**App no: 25.0092**

**Address: 41 Castle Street Clitheroe**

**Proposal: Planning permission for proposed outside seating area and new handrail**

EXISTING SITE PLAN

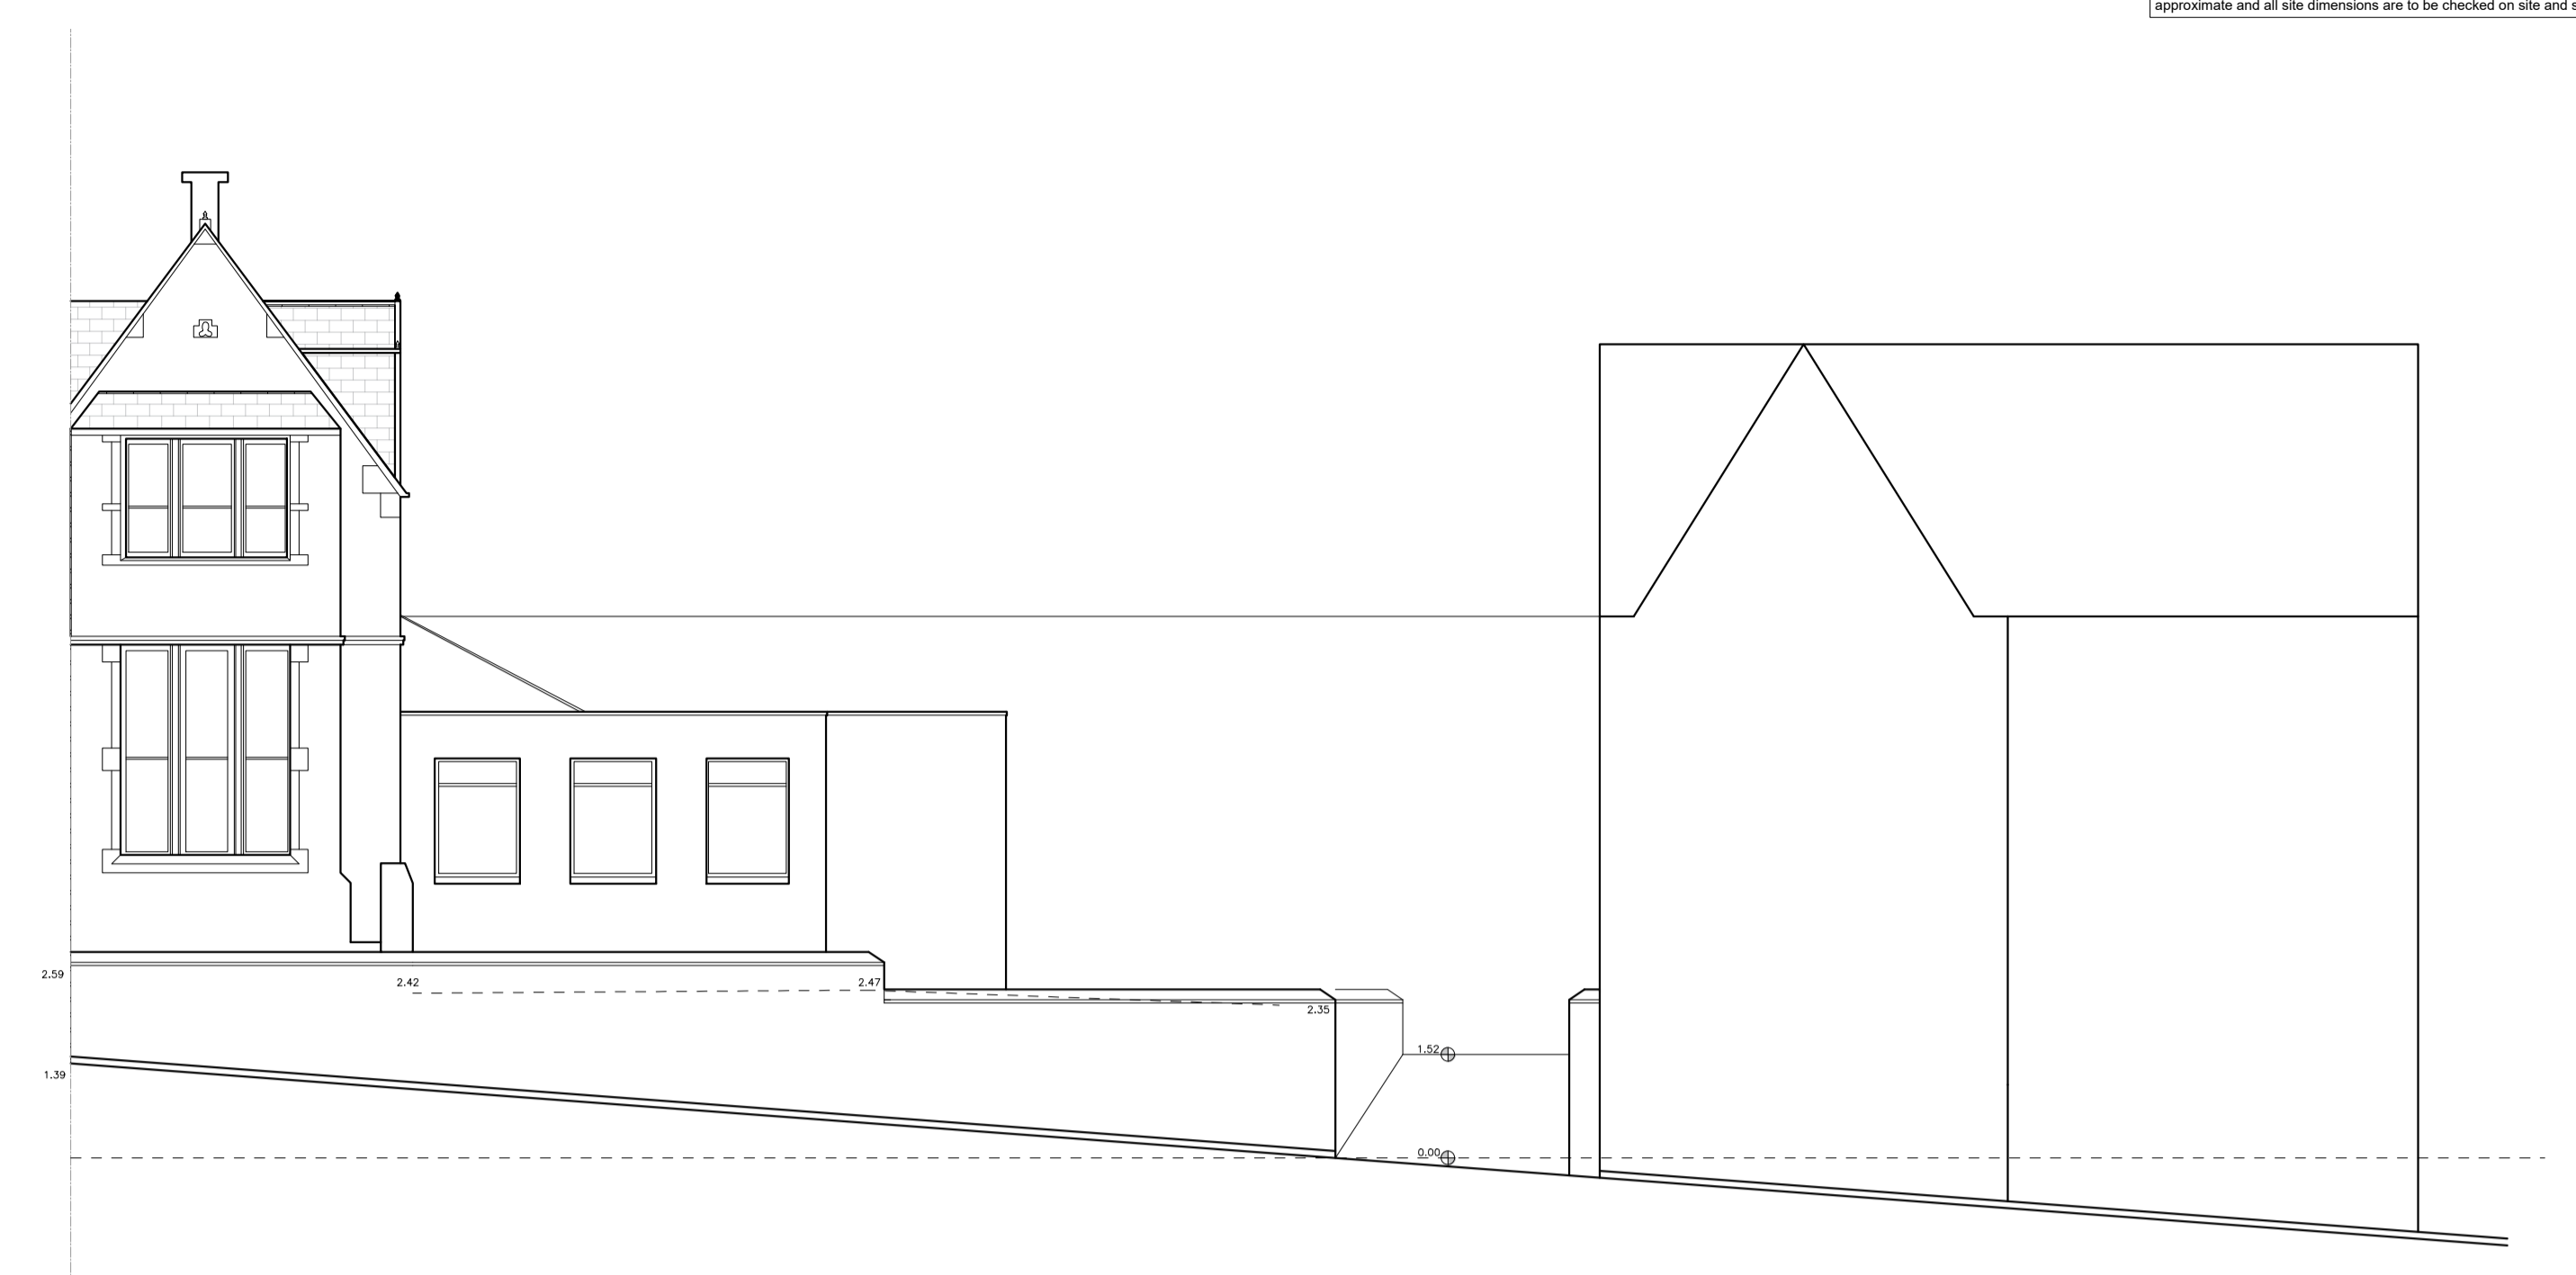
There is a vehicle access via the ramp on King Street to the external yard adjacent to the site. The ramp remains unchanged and there is an area of yard retained for vehicles to enter, turn and exit onto King Street in forward gear which is considered necessary for highway safety.

We would recommend that a walkway is marked out on the yard between the rear door and the seating area to minimise conflict with vehicles in the yard area.
